Addendum No. 1

RE: Contract # C203868
WBS # 52038.3.1
F. A. # NHPP-0040(017)
New Hanover County (I-5760)
I-40 From US-421 To 0.640 Miles East Of I-40

August 16, 2016 Letting

# BRIDGE LOCATION MAPS, JOINT REPAIR & BRIDGE APPROACH TABLES

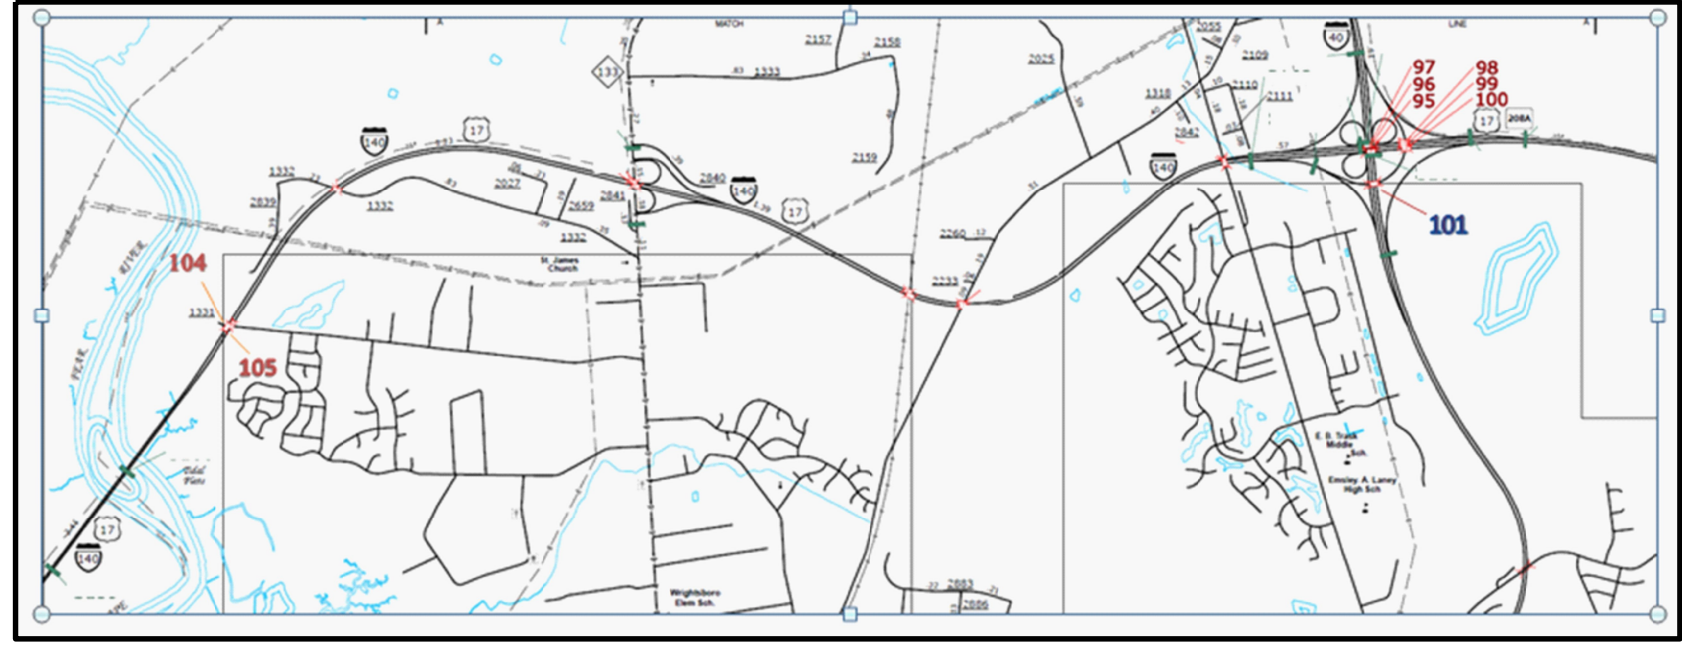
Sheet No.	Revisions
6	Revised the table for Bridge Joint Repair to reflect the below noted quantity changes for "Foam Seal Joint Replacement" and "Elastomeric Joint Repair"

<u>Item</u>	<u>Description</u>	<u>Old Quantity</u>	<u>New Quantity</u>
005-0000930000-E-SP	Foam Seal Joint Replacement	1,210 LF	724 LF
073-8882000000-E-SP	Joint Repair Using Elastomeric Concrete	408 CF	183 CF
